WEST SUSSEX COUNTY COUNCIL CONSULTATION

TO:	Arun District Council FAO: Stuart Corbey
FROM:	WSCC - Highways Authority
DATE:	1 April 2019
LOCATION:	14 Baldwin Close, Bognor Regis, PO22 6RQ
SUBJECT:	M/17/19/PL 1 No. 1-bedroom dwelling & rear extension on existing dwelling (resubmission following M/99/18/PL).
DATE OF SITE VISIT:	N/A
RECOMMENDATION:	Advice
S106 CONTRIBUTION TOTAL:	N/A

SITE PLAN 1:500

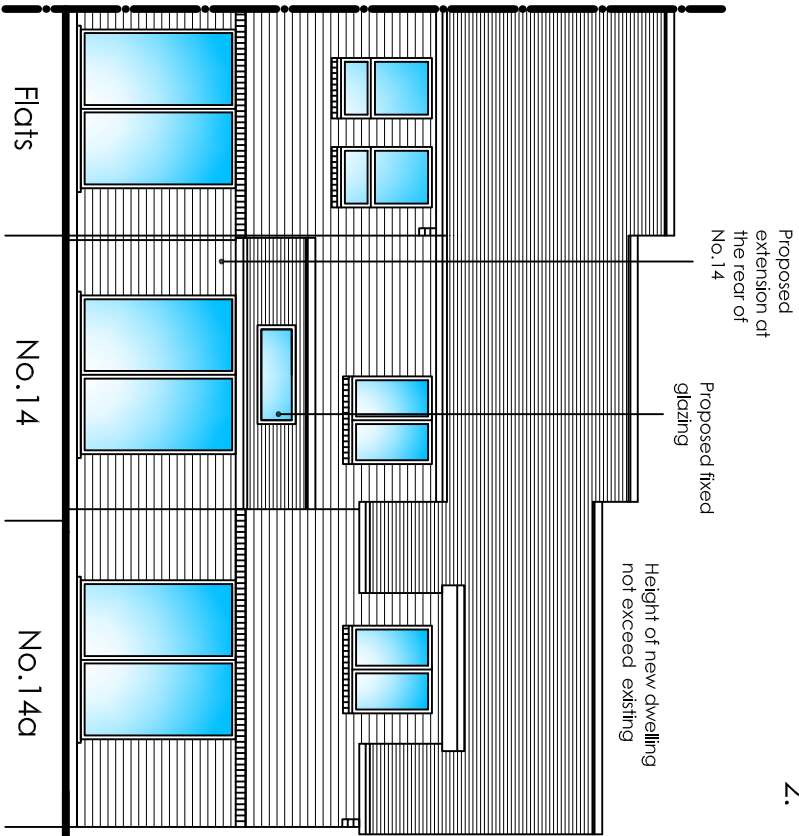
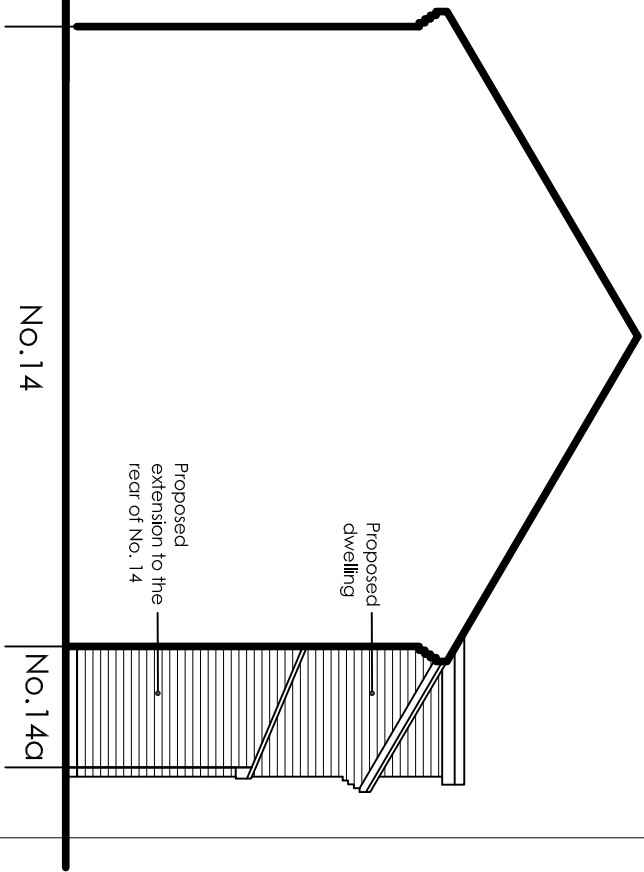
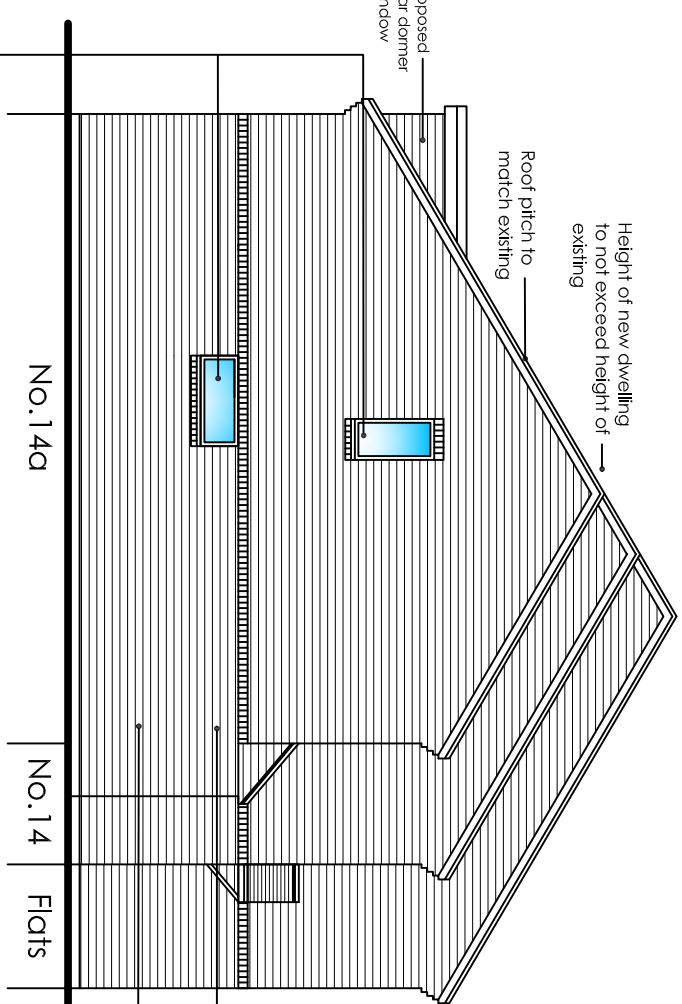
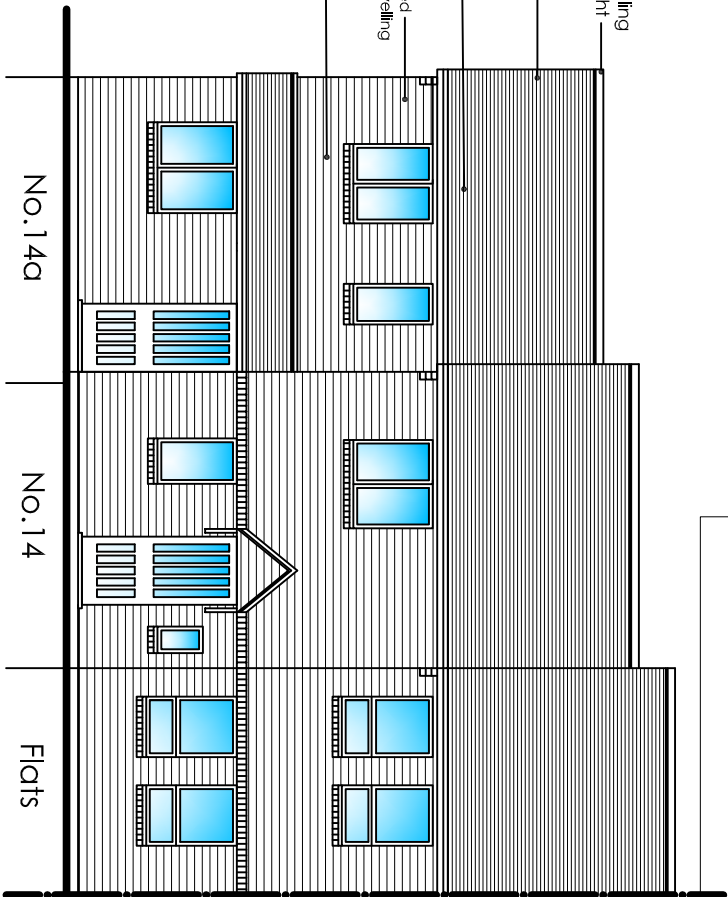
The proposed dwelling will utilise the existing vehicular access onto Baldwin Close. The application form has not indicated that a new vehicular access will be required as result of the application; however the proposed plans demonstrate that a new vehicular crossover (VCO) will be required to serve the existing dwelling. Details of the proposed new VCO to serve 14 Baldwin Close can be secured via condition. A licence will be required for the VCO and must be constructed to a specification agreed with the Local Highway Engineer.

The applicant proposes one parking space per dwelling, to be provided on the site frontage. These spaces meet the minimum specifications of 2.4 x 4.8m as set out in Manual for Streets (MfS). The WSCC parking demand calculator expects that a minimum of three parking spaces will be required for this development in this location - one space for the proposed dwelling and two for the existing dwelling. The Planning Authority may wish to consider the potential impacts of this development on on-street car parking from an amenity point of view. A turn on site would be preferable although this is clearly not achievable within the site constraints. Neighbouring properties share similar arrangements without evidence of safety concern.

No part of the development shall be first occupied until such time as the vehicular access to 14 Baldwin Close has been constructed in accordance with plans and details submitted to and approved in writing by the Local Planning Authority.

No part of the development shall be first occupied until the car parking spaces have been constructed in accordance with the approved plan. These spaces shall thereafter be retained at all times for their designated use.
